Reviewed for Code Compliance  
Inspections Division  
Approved with Conditions

KITCHEN CABINETS

FIRST FLOOR  
521 CUMBERLAND AVE

S21 Cumberland  
1st floor newly framed bedroom wall

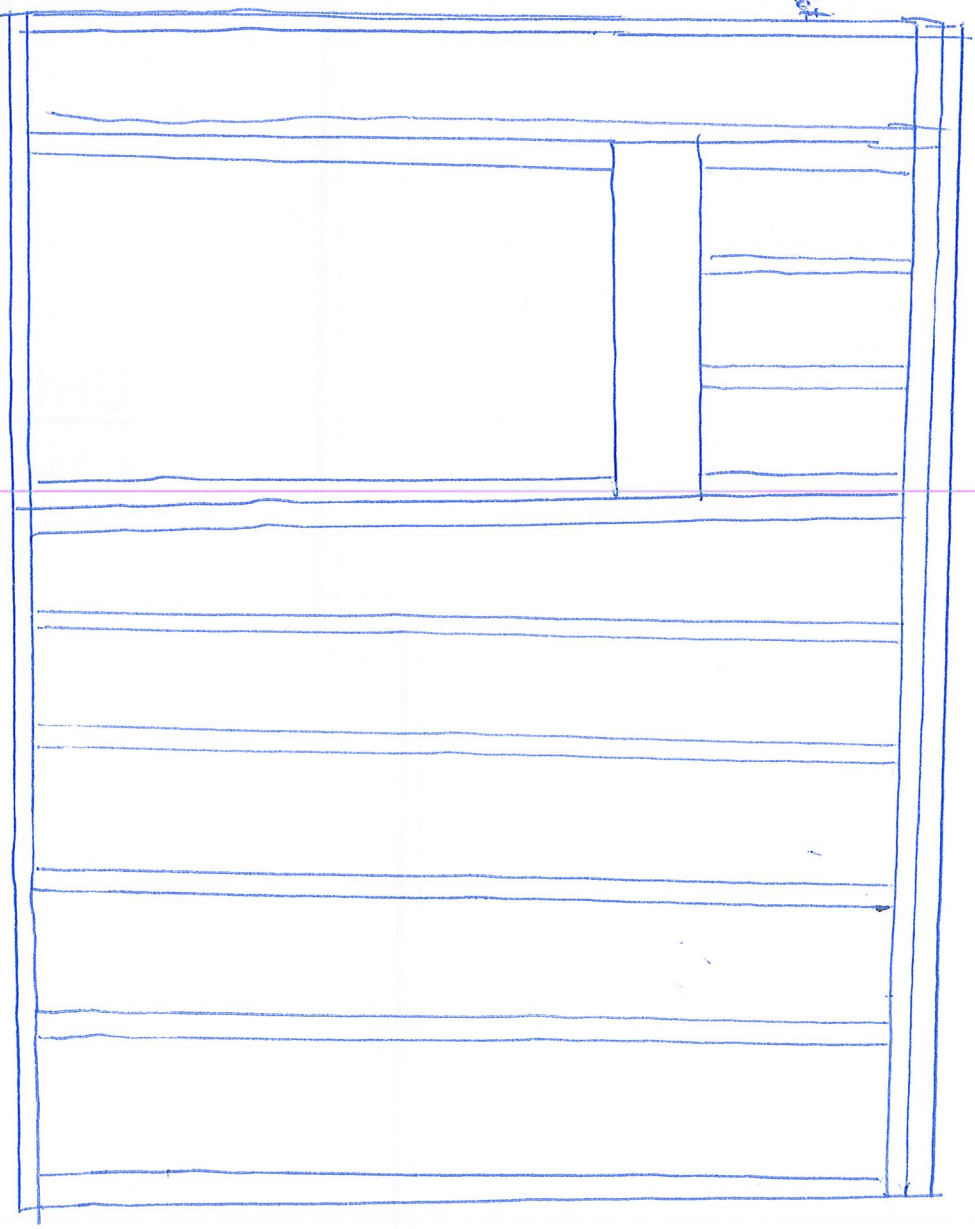
-  5/8" fire-x drywall on both sides
-  1/2" drywall to replace existing plaster

Some ceiling patches, Kitchen, bedroom #1, bath and hall ceiling to be replaced with 5/8 drywall where plaster was removed
